DECISION DELEGATED TO HEAD OF PLANNING

Application No: H12-0119-24 **Applicant:** Mr W Eagling

Proposal: Details of site levels & floor levels, window opening mechanisms & the opacity of proposed glazing & boundary treatment (Conditions 3, 4 & 5 of H12-0883-23)

Location: Land Adjacent To Sunningdale 66 Gedney Road Long Sutton

EAST ELEVATION 1:100

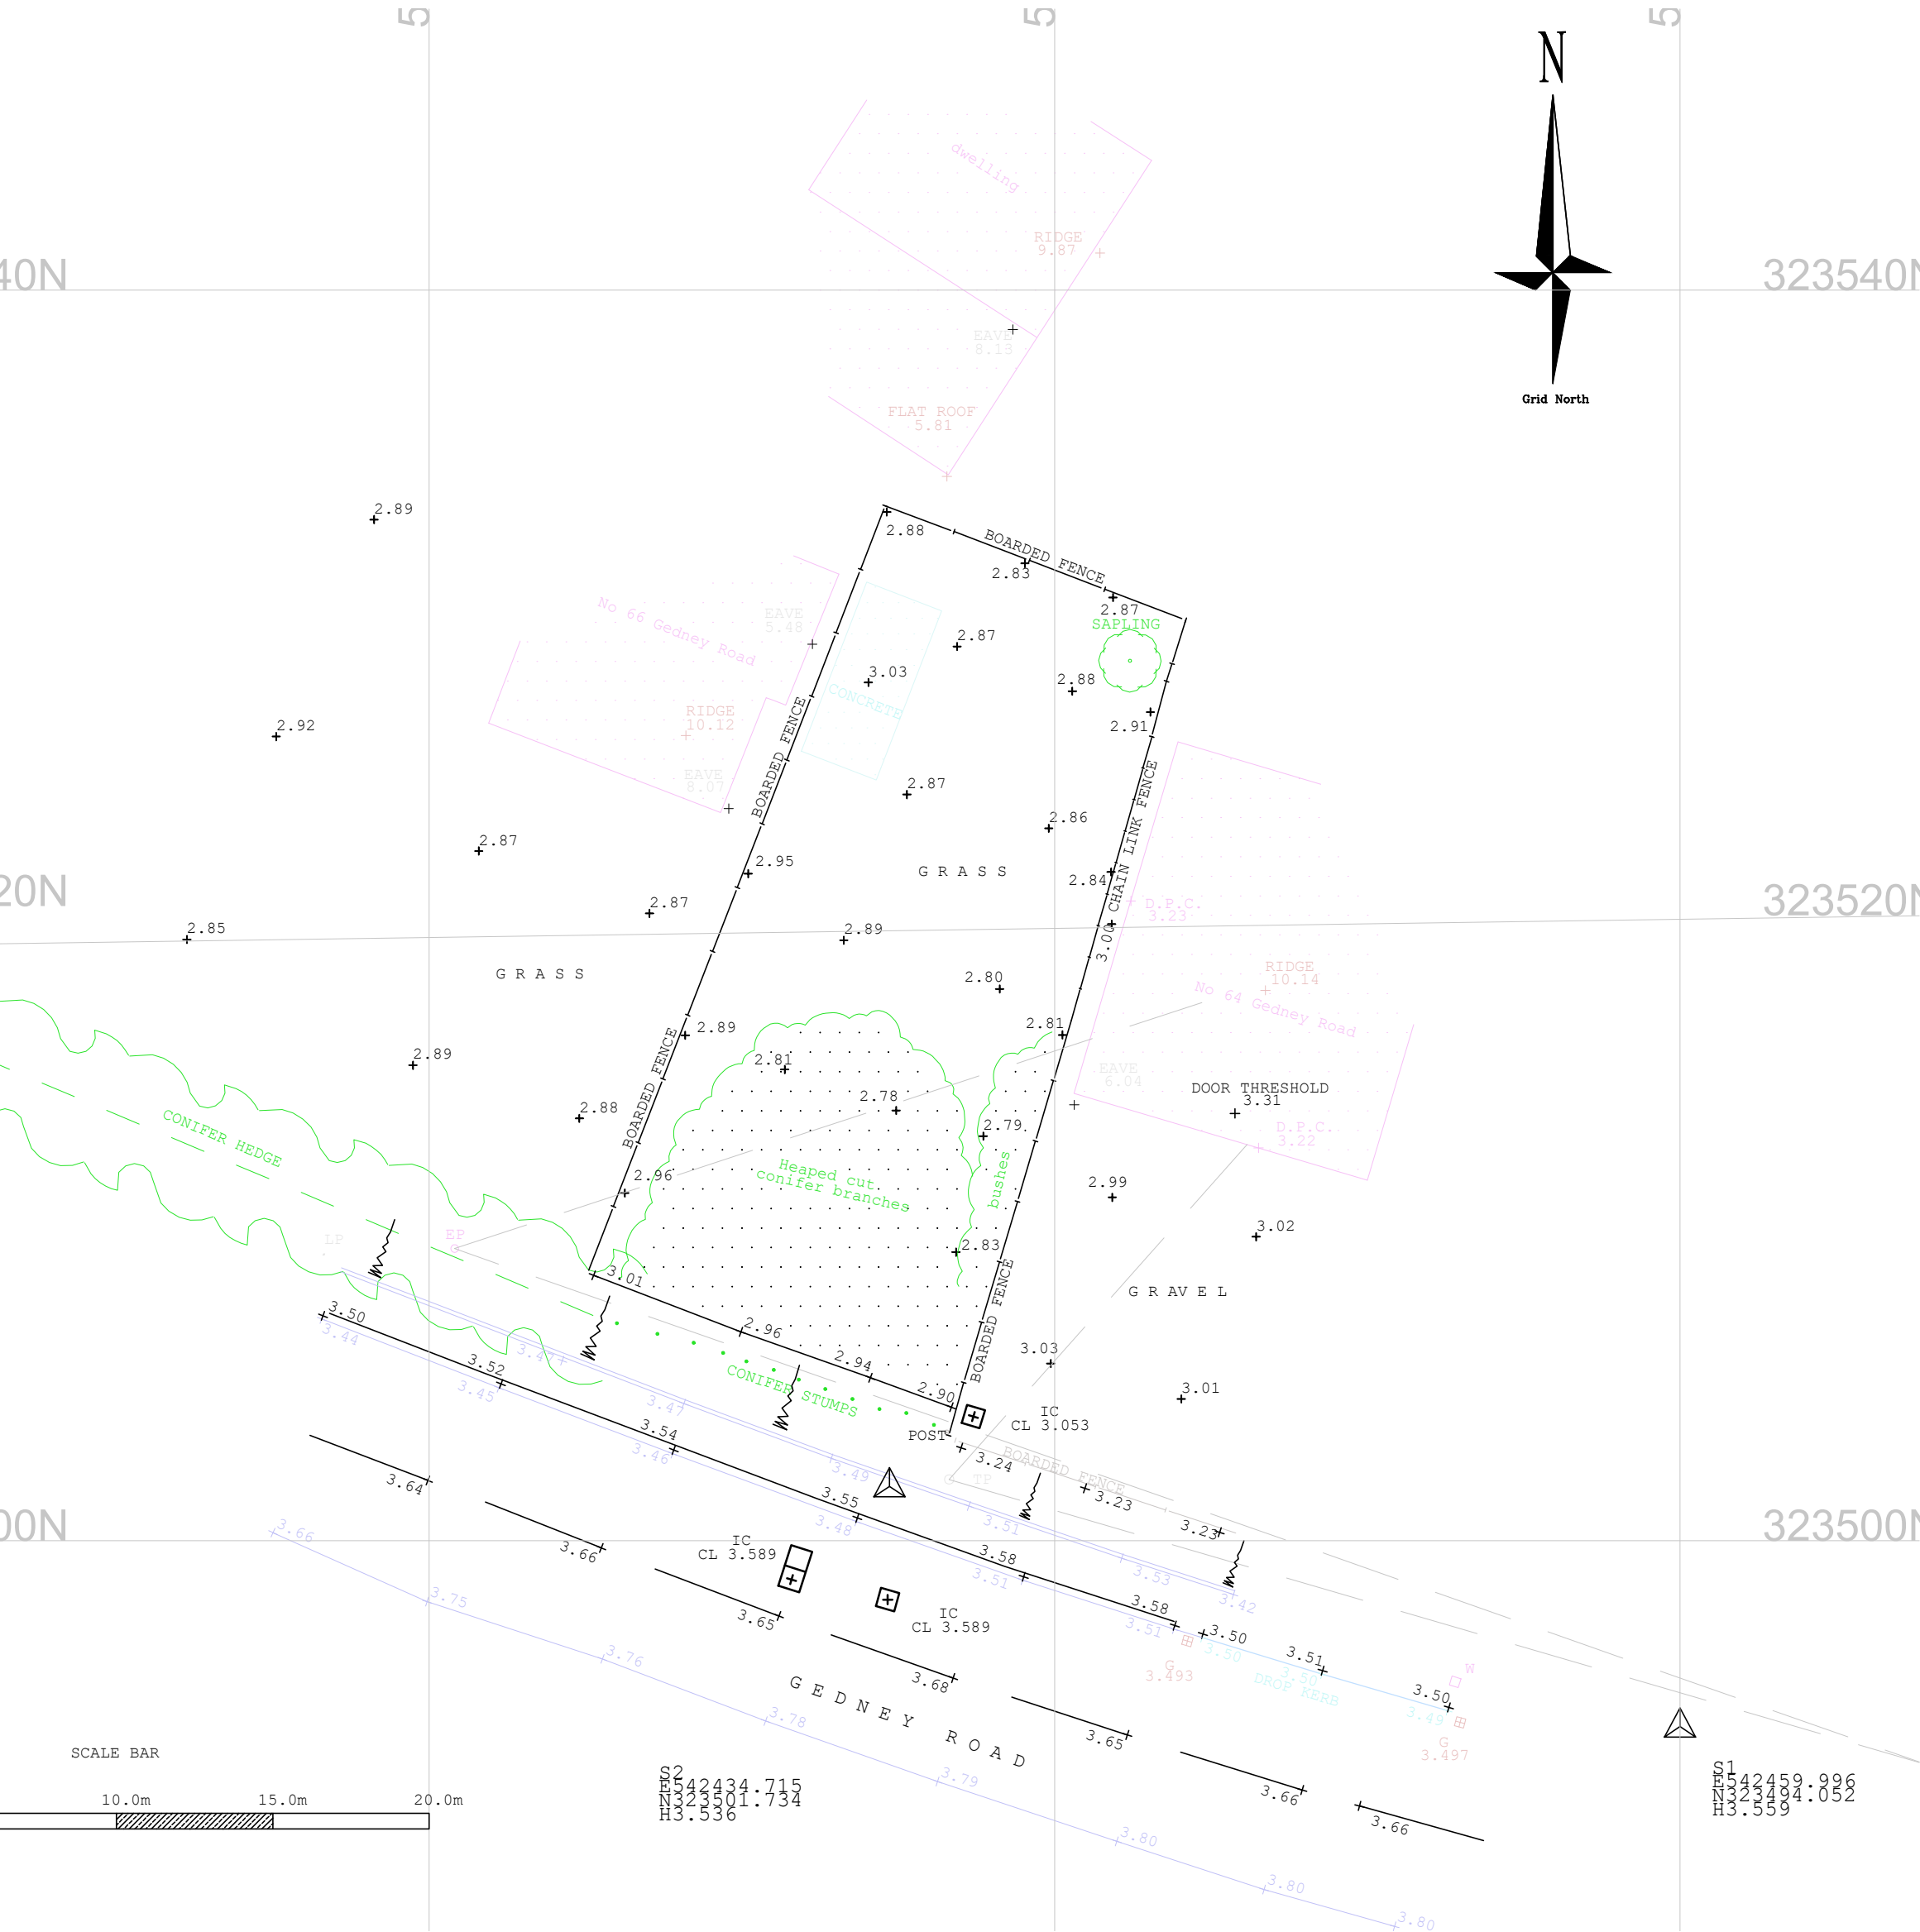
The applicant has provided details of the proposed windows, particularly that of the east facing window. This was requested as it was a concern of the LPA that the east facing window could potentially raise an overlooking risk to the nearby residential property. Therefore, the LPA is satisfied that this window shall be obscured to at least Pilkington Level 5, shall not be opening below an internal FFL of 1.7m and shall only be capable of bottom-opening to a maximum of 100mm from the frame. The local planning authority is satisfied that this protects the residential amenity of 64 Gedney Road, with regards to privacy.

PROPOSED SITE PLAN 1:200

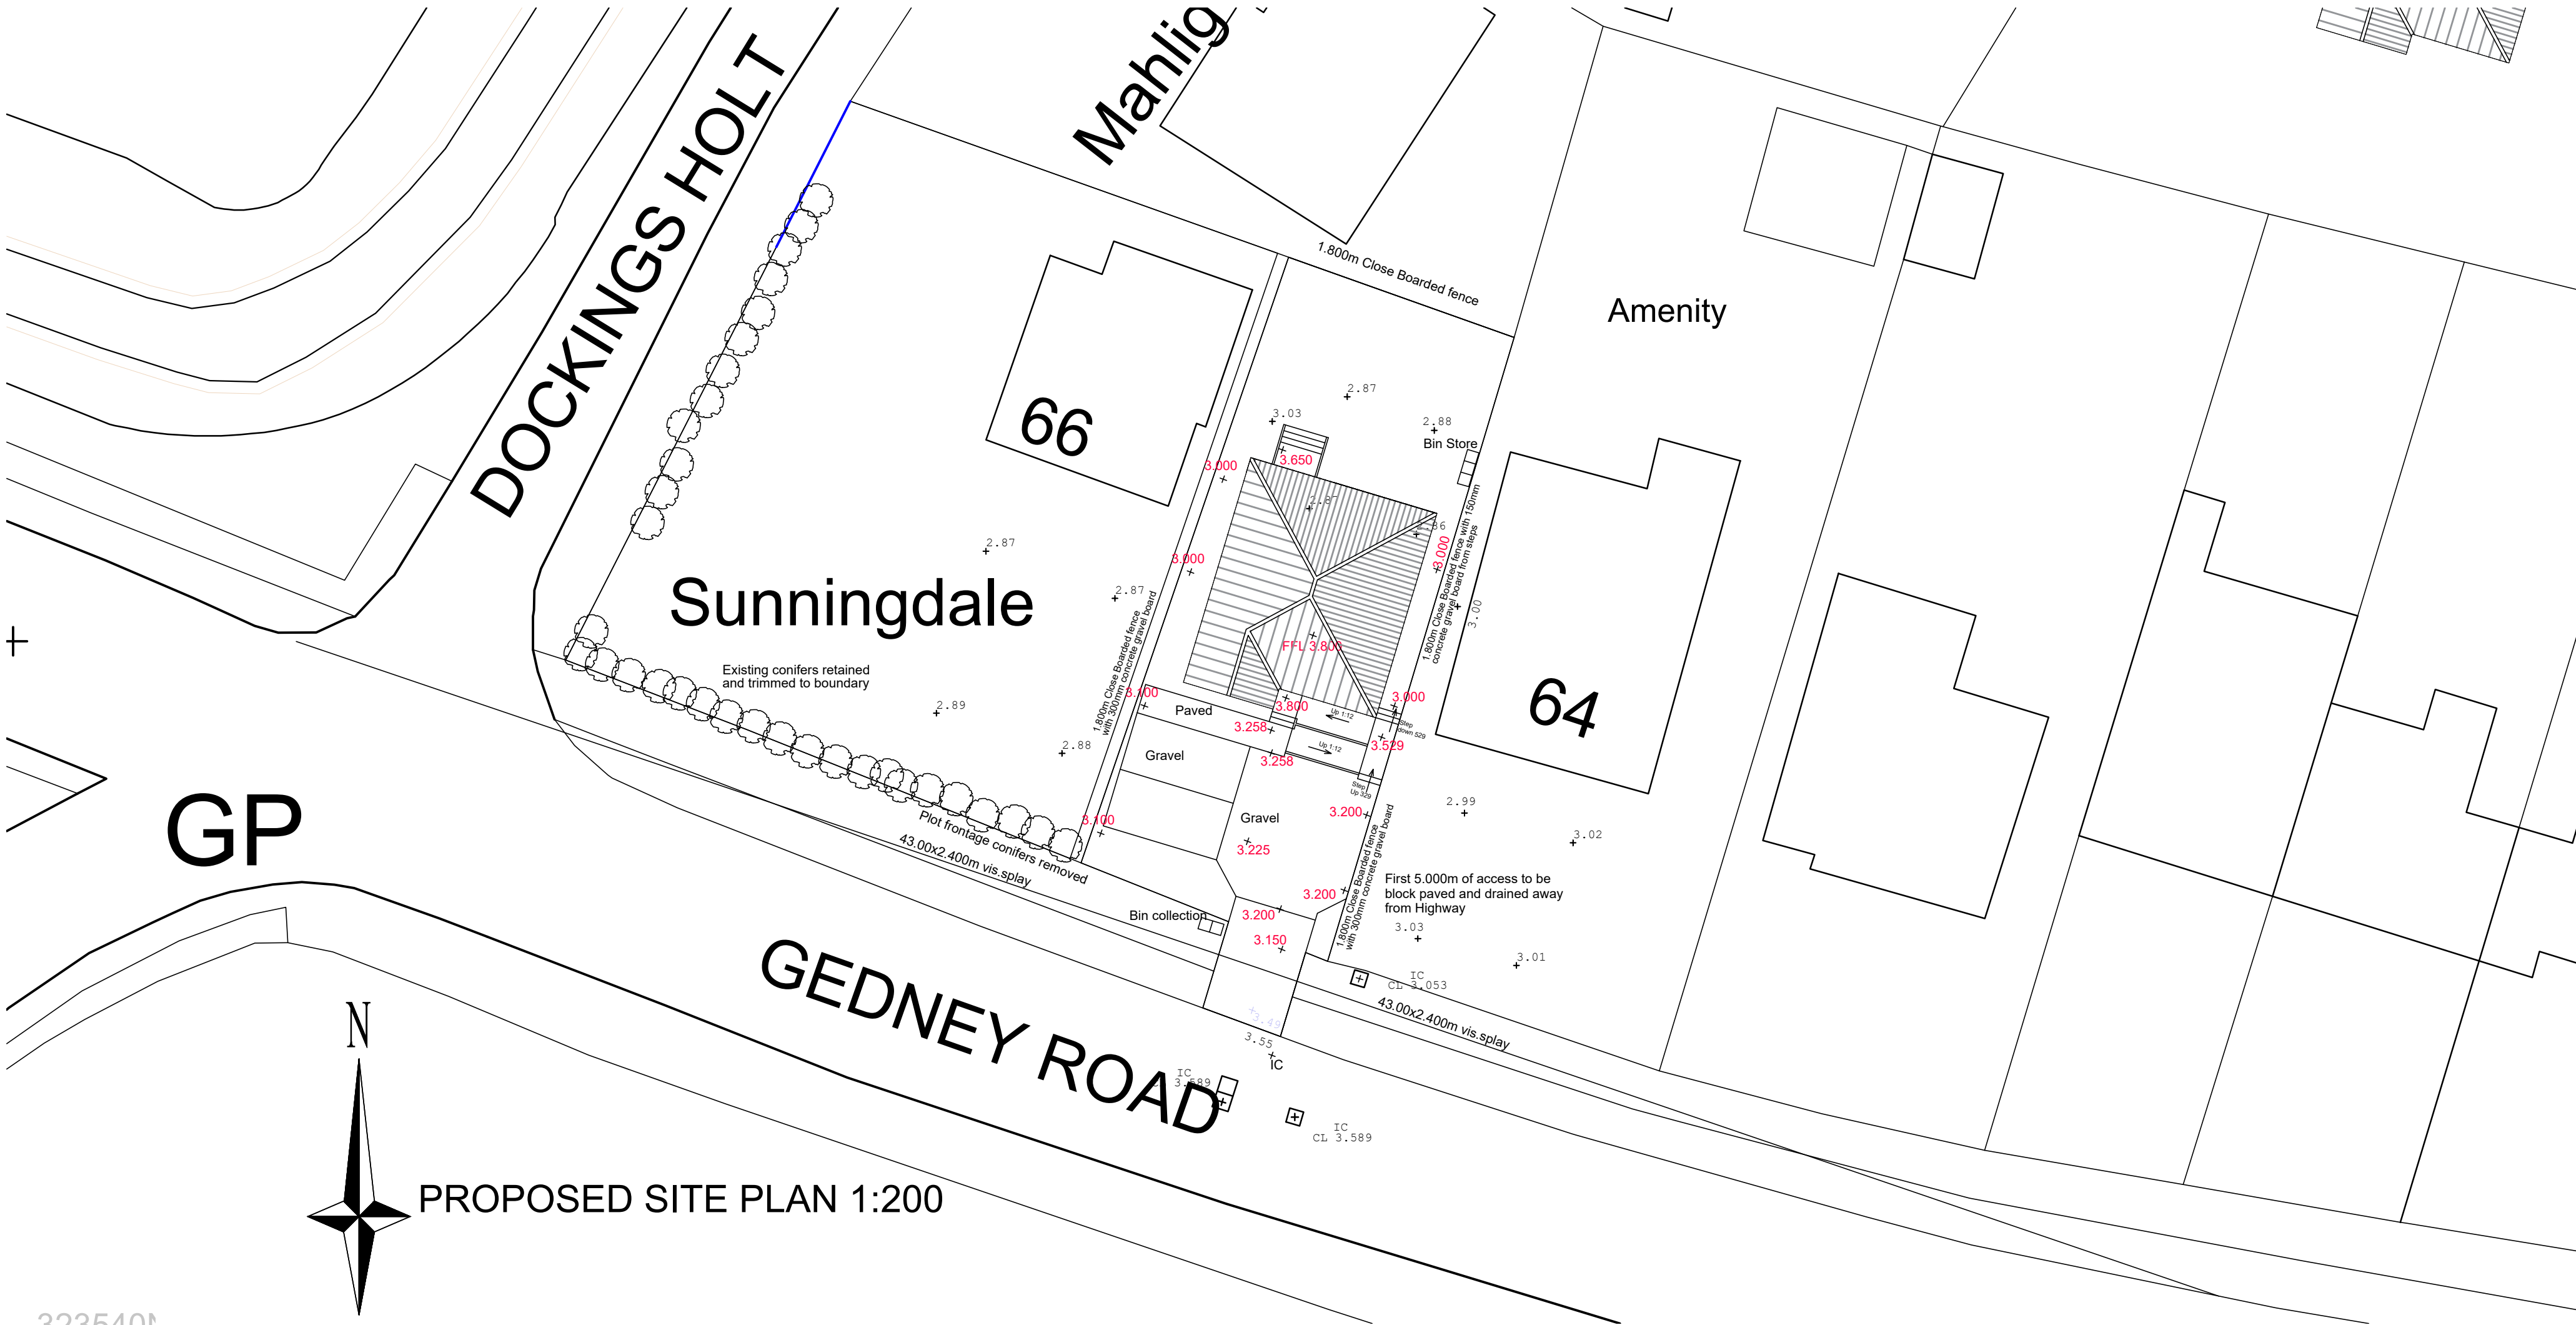
The applicant has provided details of the final FFLs for the site. This condition was originally applied to ensure that the FFLs were tightly confirmed, and the local planning authority is therefore satisfied that the applicant has demonstrated their intention with regard to such levels, and in line with the

assessment given at the time of the determination of the original application, the local planning authority deems that these details are satisfactory and therefore, the condition may be discharged.

Site section 1:100

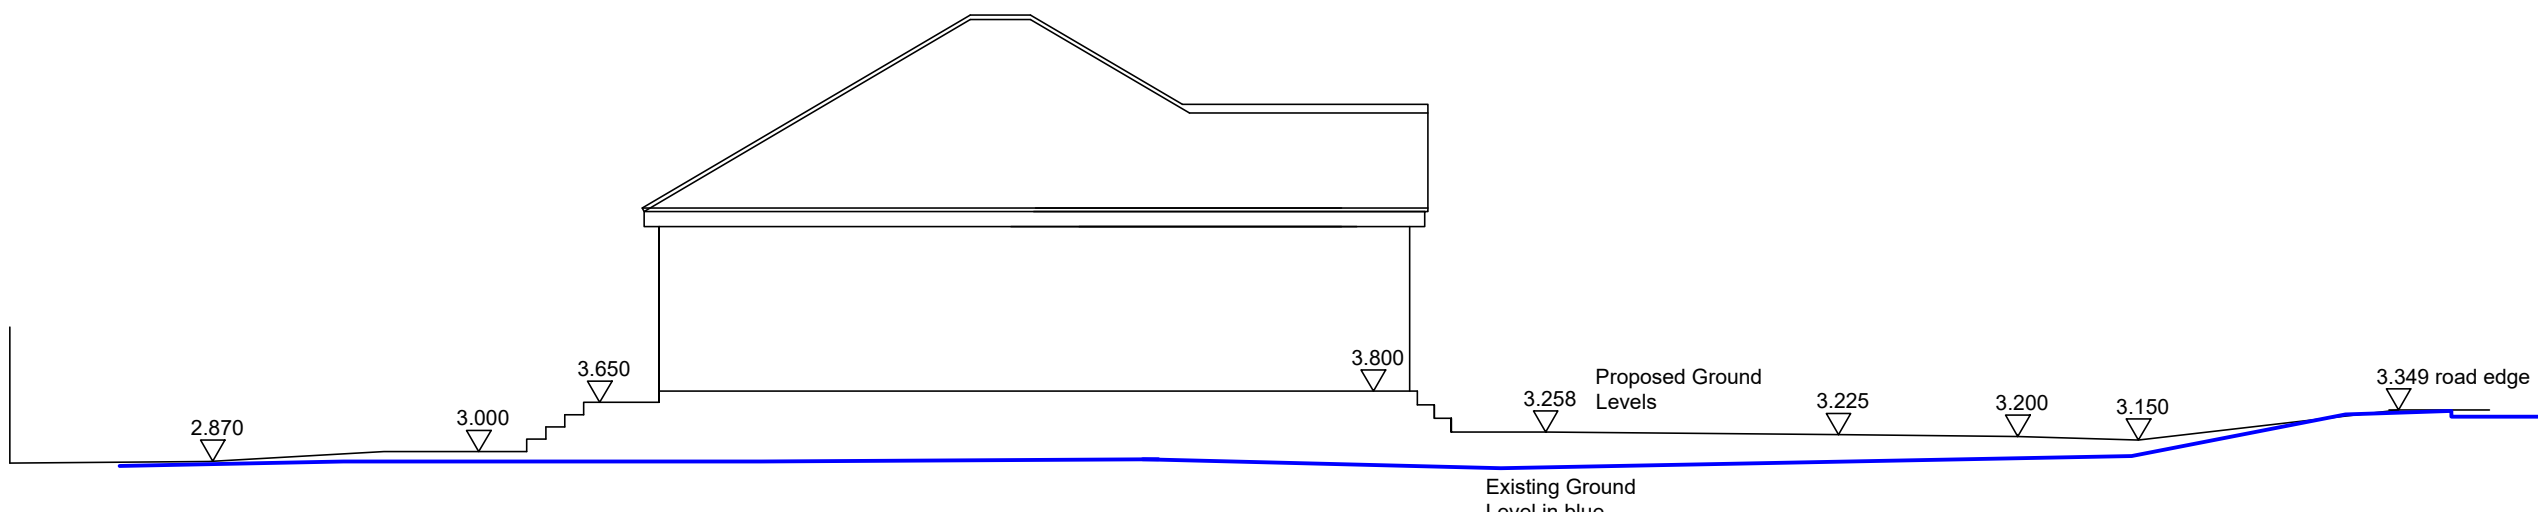
The applicant has confirmed that the means of enclosure shall be a 1.8m close-boarded fence, with a 300mm concrete base, forming a 2.1m high fence. In conjunction with the restrictive viewing measures employed upon the east facing window of the property, the local planning authority is satisfied that this arrangement is suitable in terms of design and also protects the privacy of surrounding properties, most especially 64 Gedney Road. Therefore, the LPA considers the details provided to be acceptable, and therefore, this condition may be discharged.
